Application by Highways England for an Order Granting Development Consent for the M25 Junction 10/A3 Wisley Interchange

Request for further information

M25 Junction 10 / A3 Wisley Interchange Improvement project

The Examining Authority's third written questions and requests for information (ExQ3)

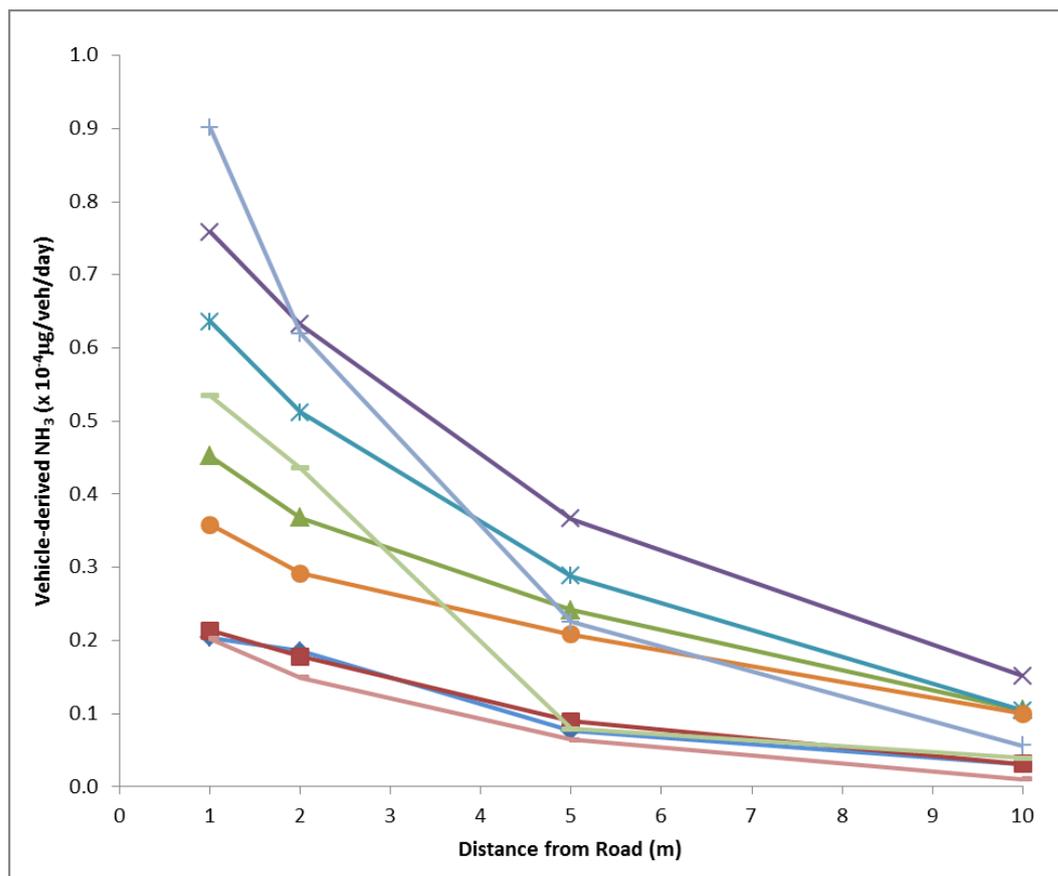
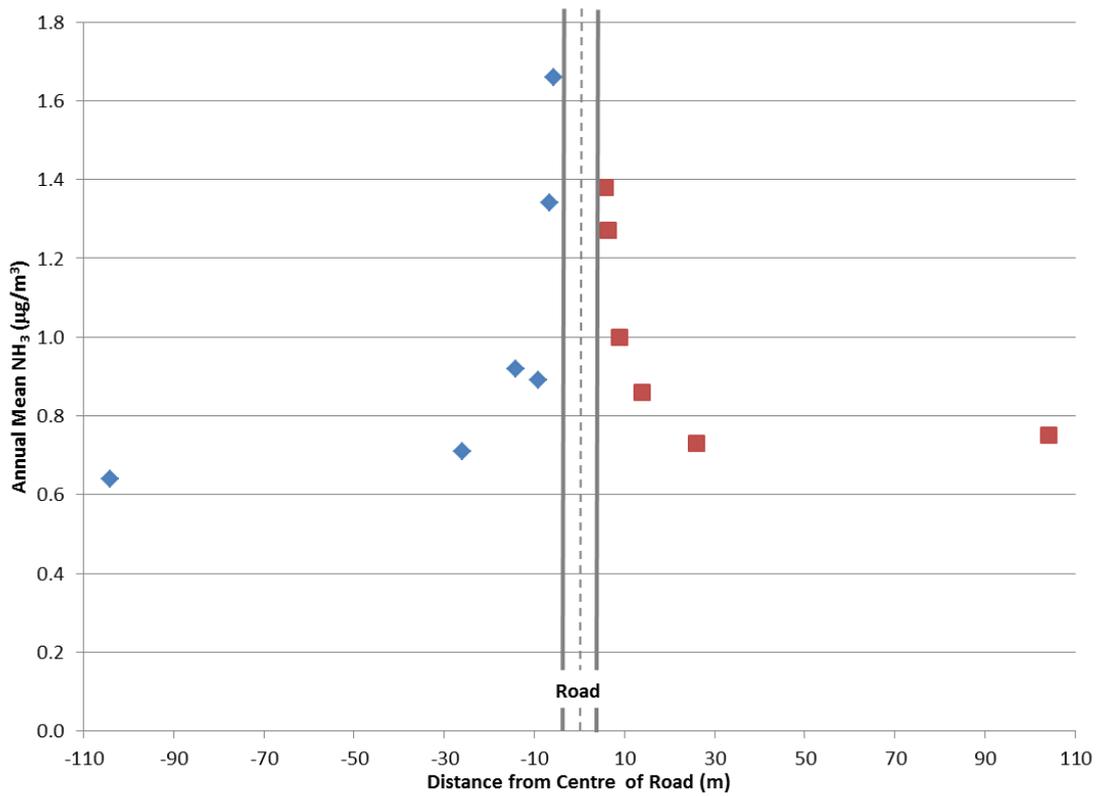
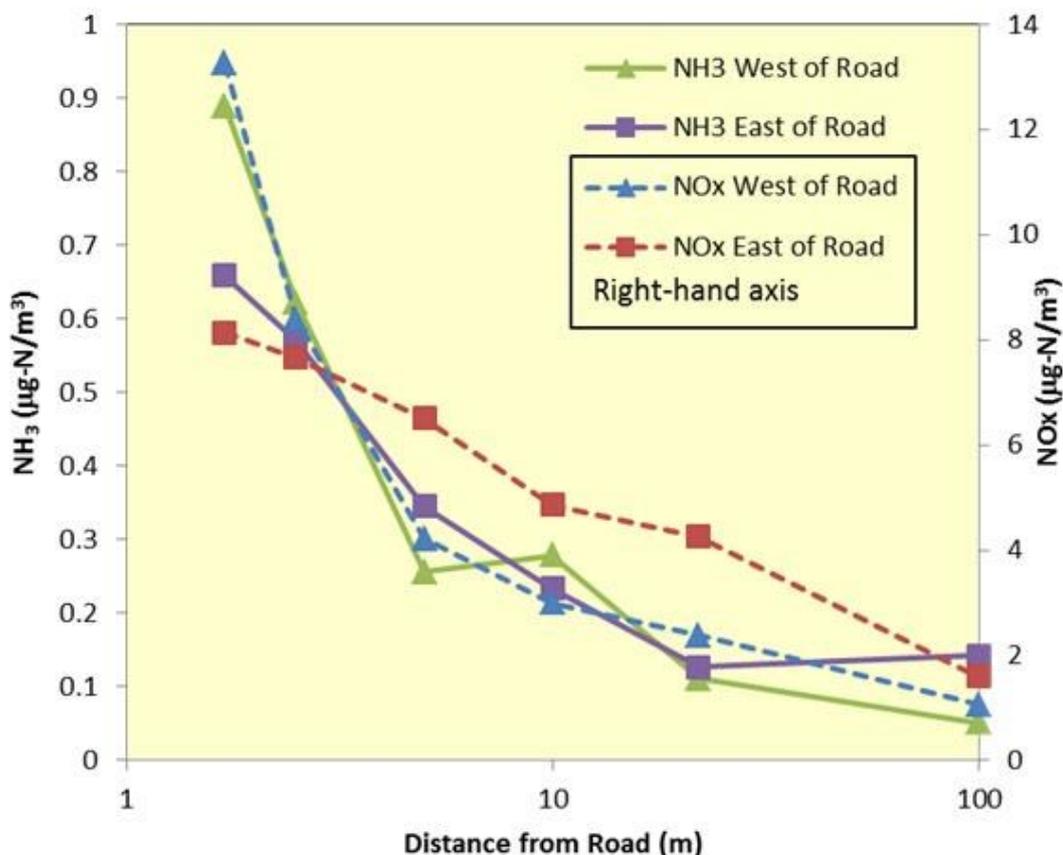
3.4.2	RHS	Given the results presented in Figures 1, 2 and 3 of [REP5-049] what implications in regard to ammonia concentrations do you consider there would be as a result of the Proposed Development for the TBH SPA, taking into account the specific characteristics of this part of the SPA, its spatial relationship with the strategic road network, and the nature of the qualifying species of the TBH SPA.

Figure 1: Replacement Land locations and existing special category land

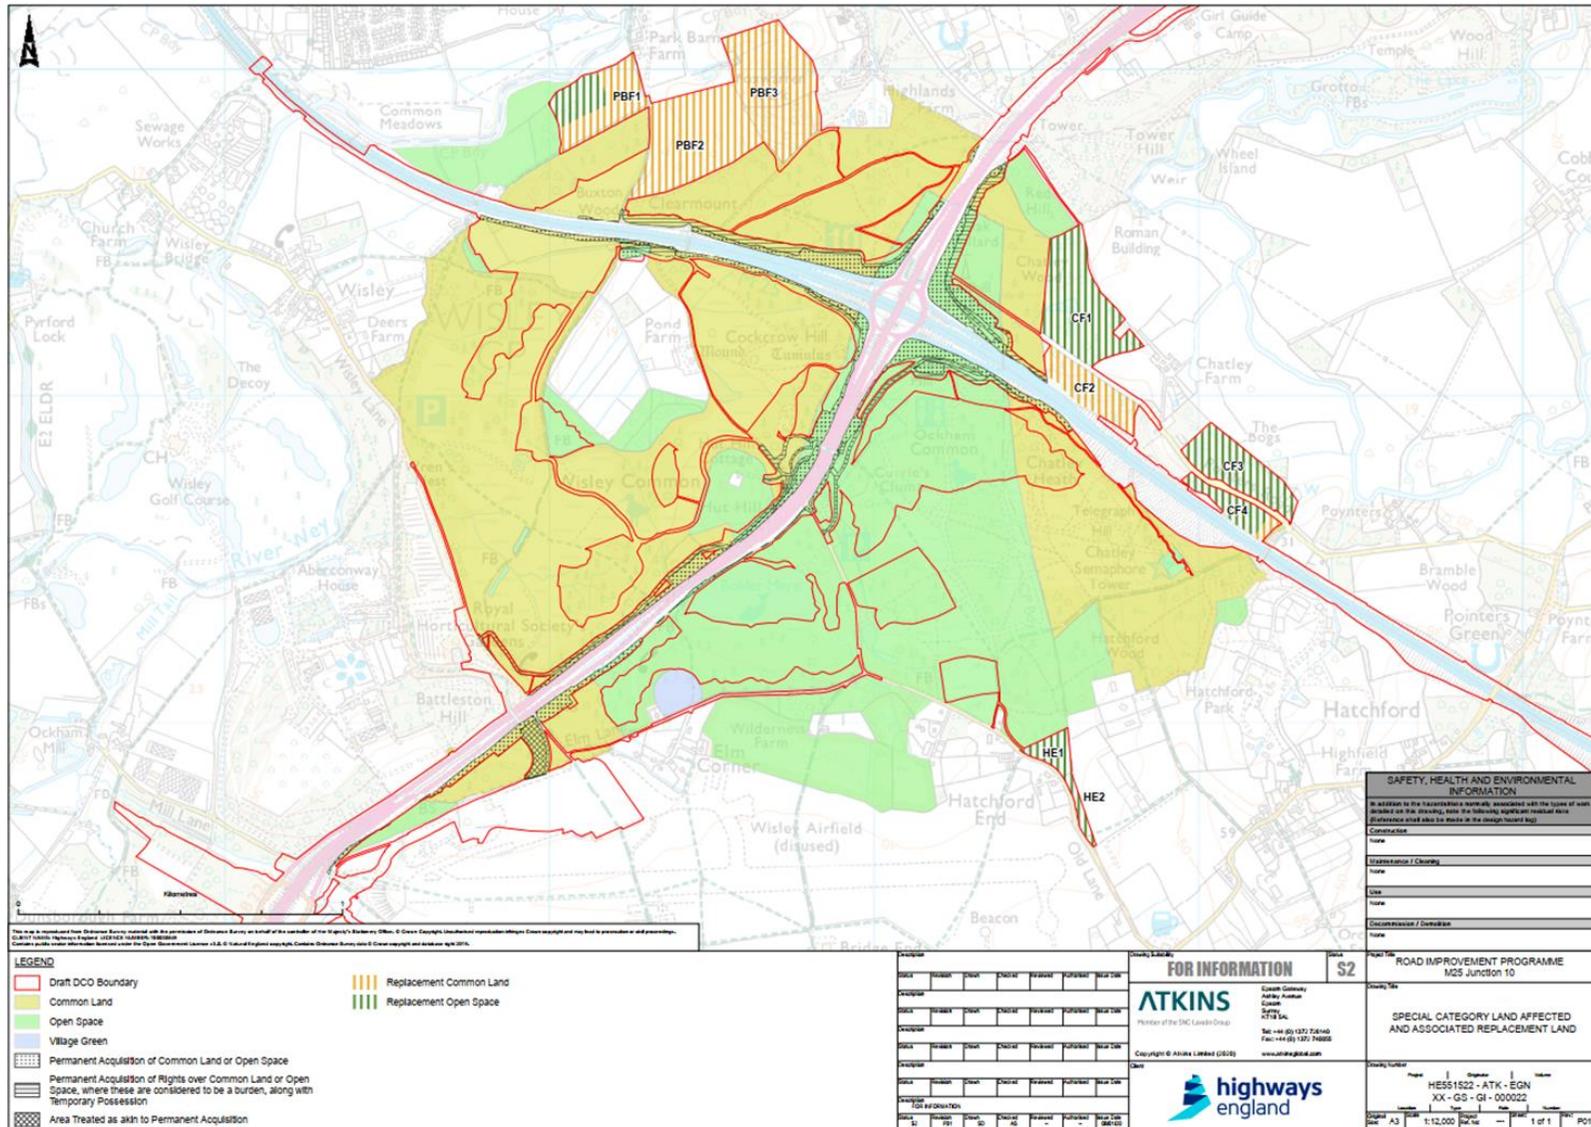
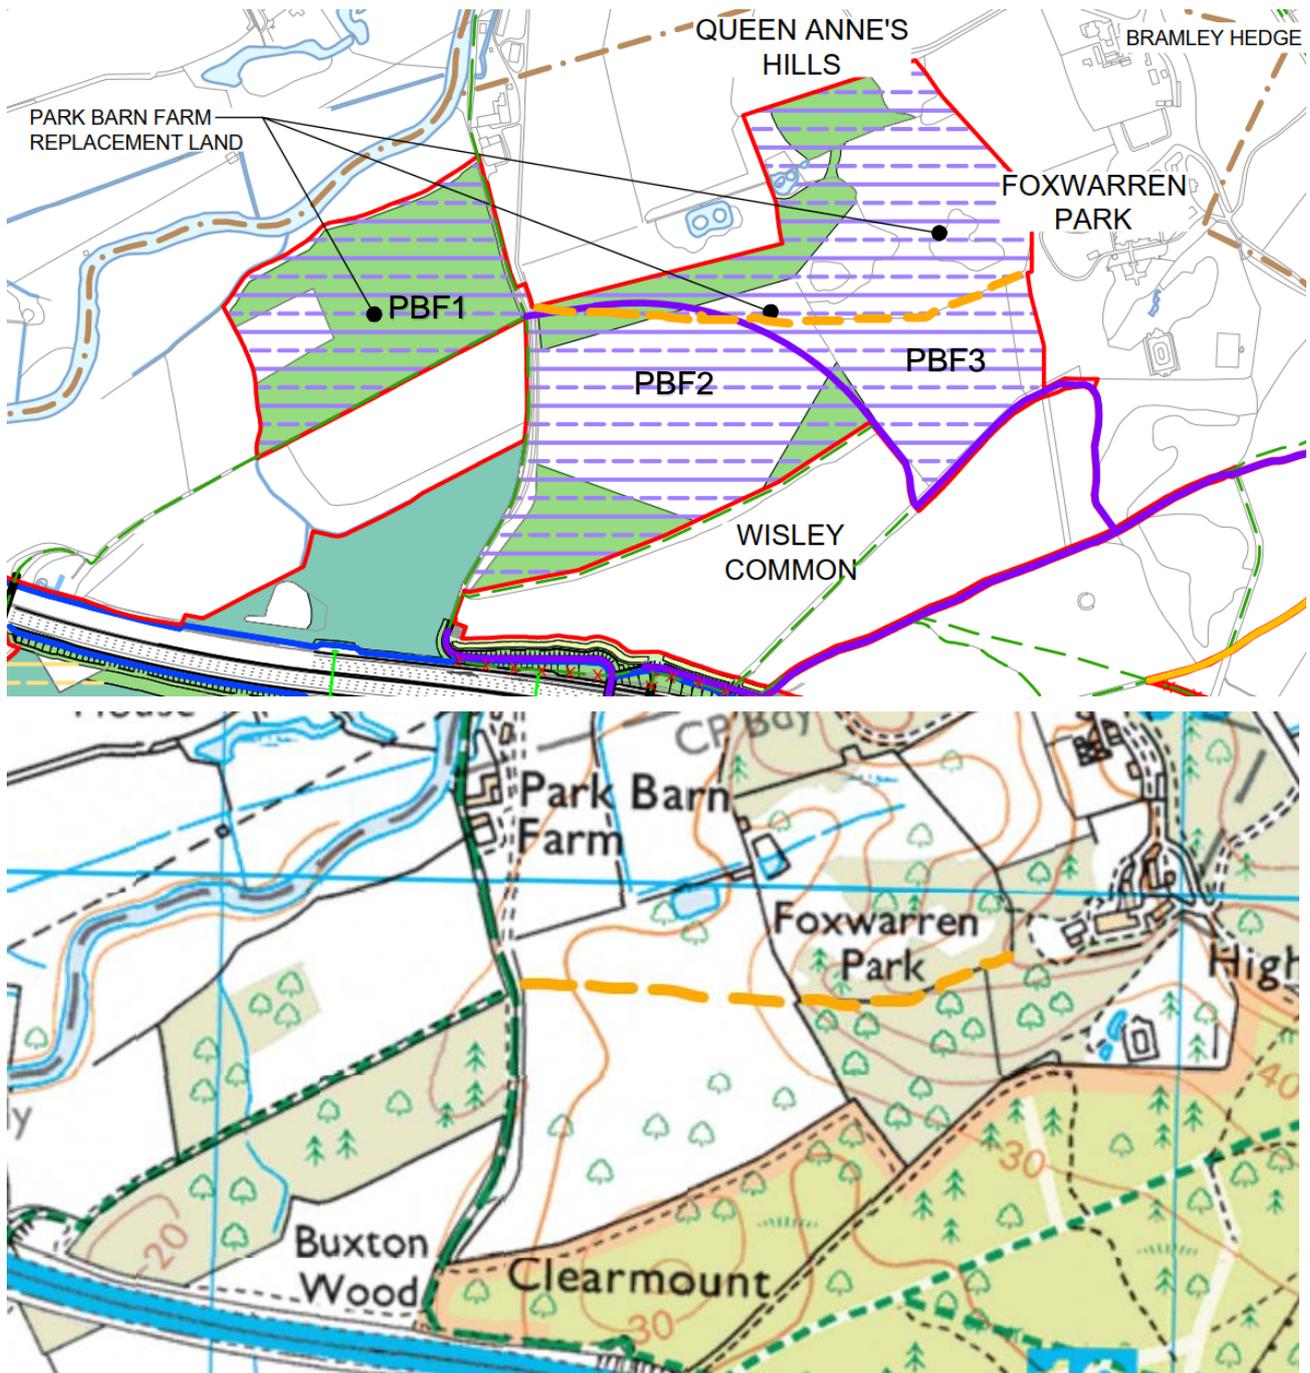
3.9.3	SCC, EBC and GBC	<p>With respect to the proposed provision of replacement land in exchange for SCL and the range of possible options outlined in Table 1 of the 'Note on Implications of Potential Reduction in Replacement Land' [REP5a-012], please:</p> <p>a) identify the three SCL options in Table 1 that you most and least favour, ranked in order of most/least preferred; and</p> <p>b) explain the reasons for those choices.</p> <p>Without prejudice to any representations you have made at earlier deadlines for this Examination concerning the provision of SCL replacement land, in answering this question each local authority is requested to disregard any 'in-principle' type objections they might have to a reduction in the target ratios stated by the Applicant in AS-005. Additionally, in answering this question each local authority is requested to take account of the following factors:</p> <p>i. the underlying purposes for having the Common Land and Open Space;</p> <p>ii. any user benefits and/or disbenefits in terms of the proximity of any</p>
